Consultation Response from KC, Conservation and Design**2020/93674 Gill Birks Farm, 5, Gill Birks, Meltham, Holmfirth, HD9 4DZ****Variation of condition 2. (plans and specifications) on previous permission no. 2020/91235 for erection of extension and alterations to attached garage/workshop to extend living accommodation (Listed Building within a Conservation Area)****Date Responded: 26/11/20****Responding Officer: Craig McHugh****Responding Ref: ME 4/59**

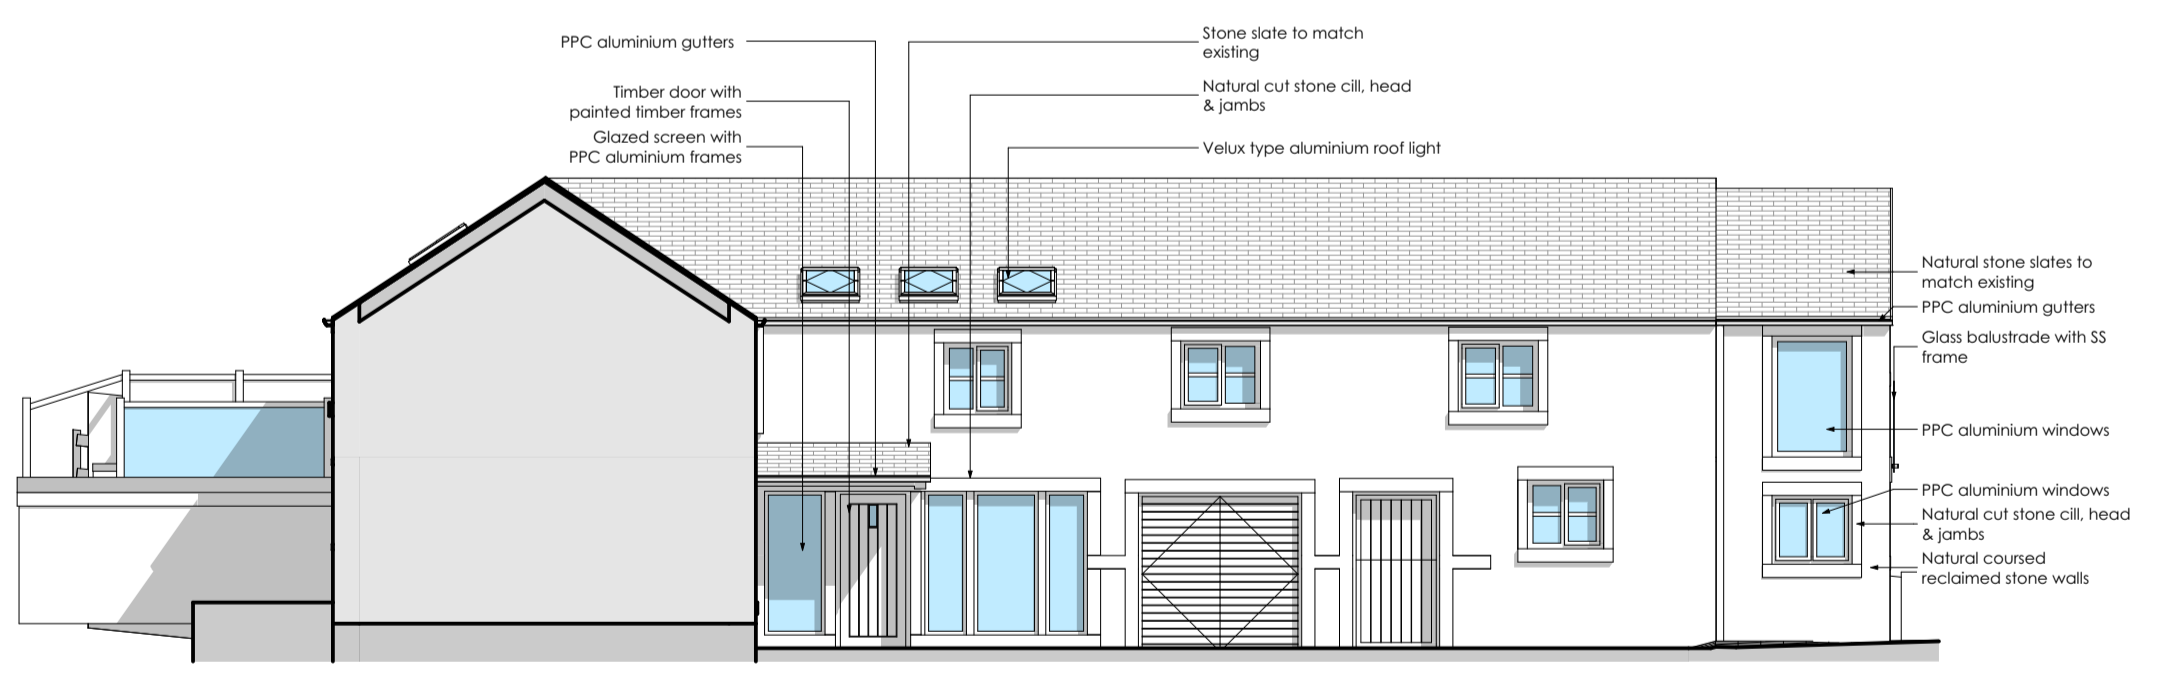
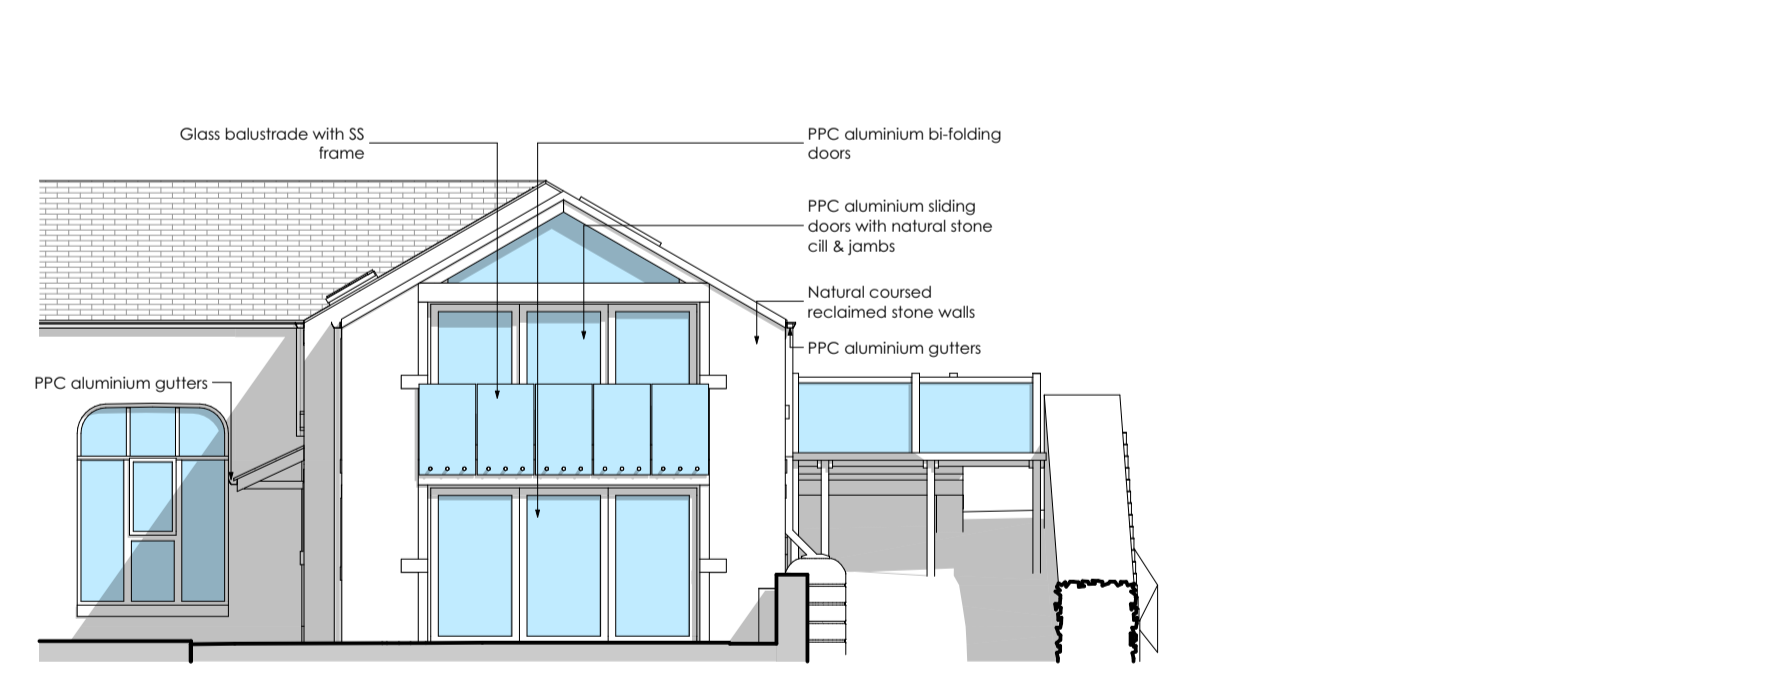
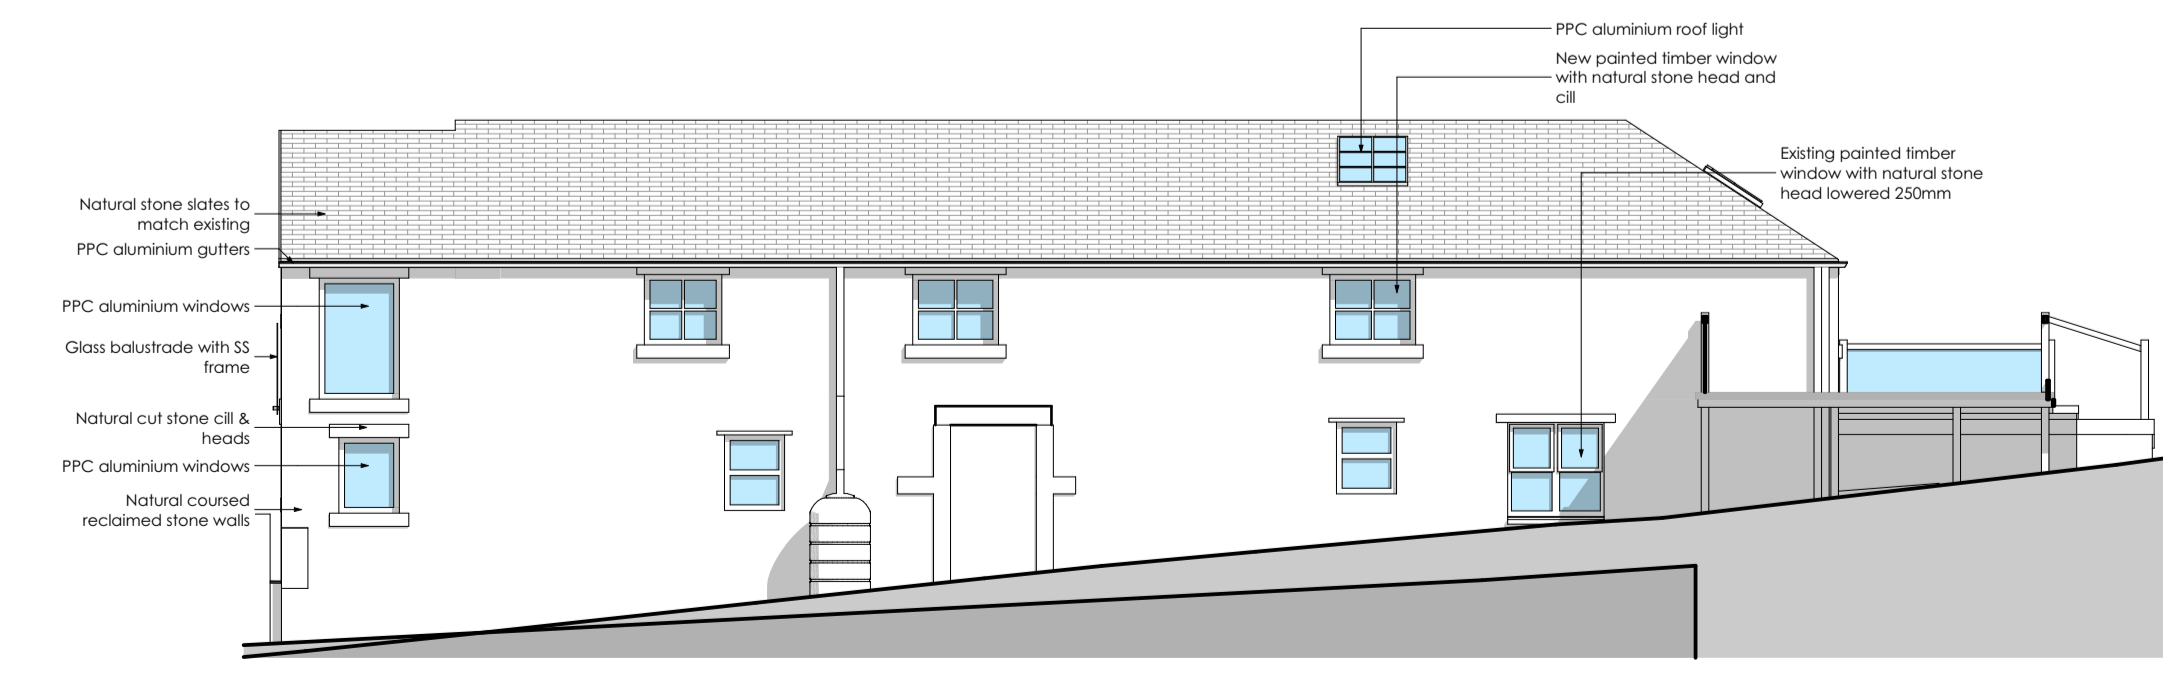
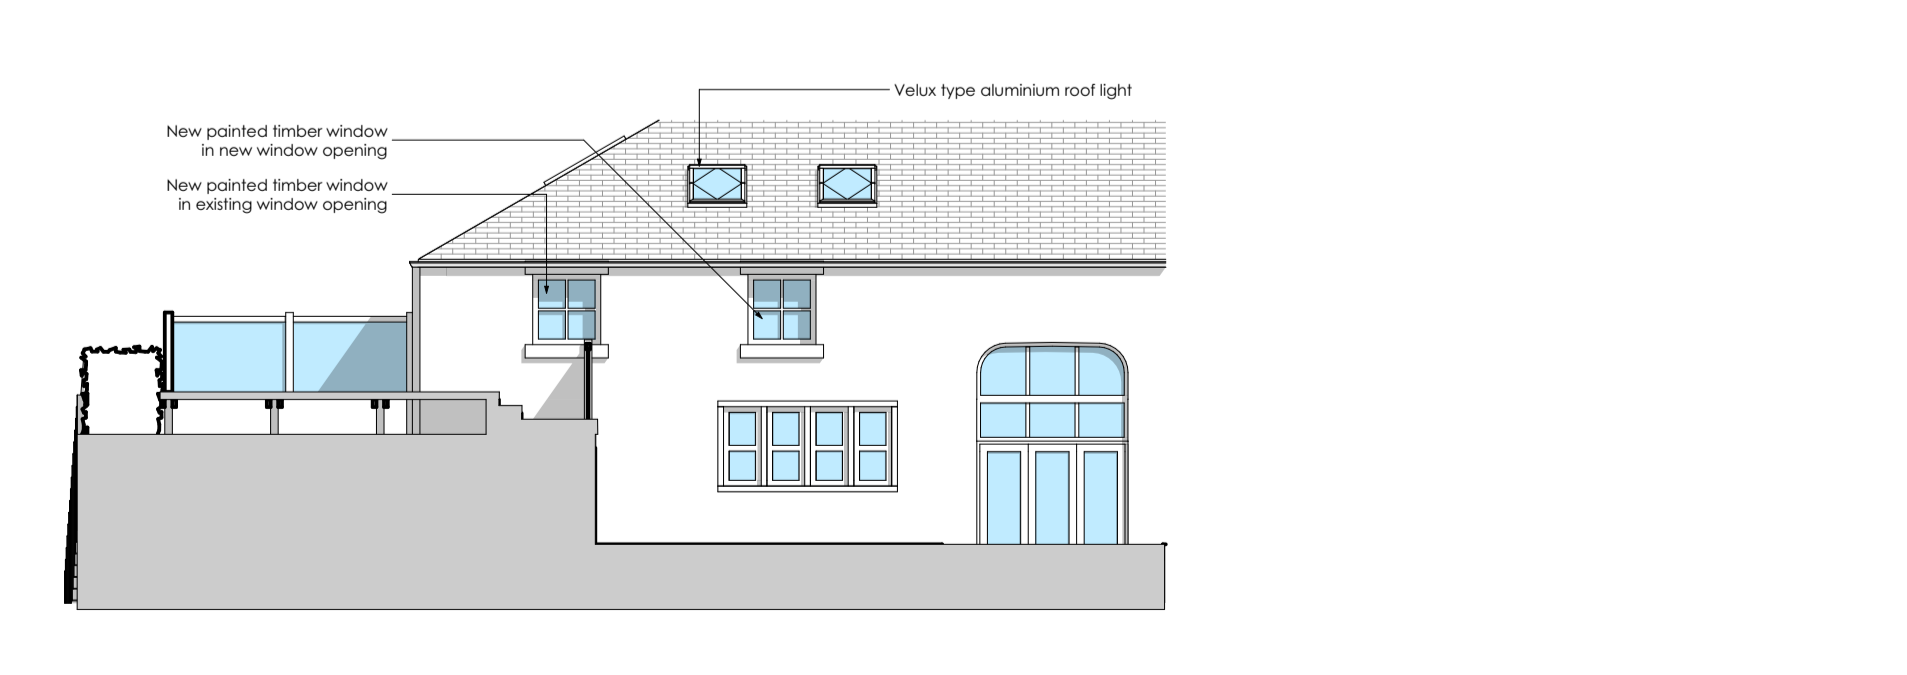
The oak framed porch should be omitted from the front elevation, this detracts from the simple linear form of the building and domesticates what was formerly an agricultural building. The doors to the north gable end of the building to the ground and first floors should relate to each other. The doors to the first floor should be divided into three sections, not two. Subject to the proposals being revised as proposed above, Conservation and Design have no concerns on heritage grounds.
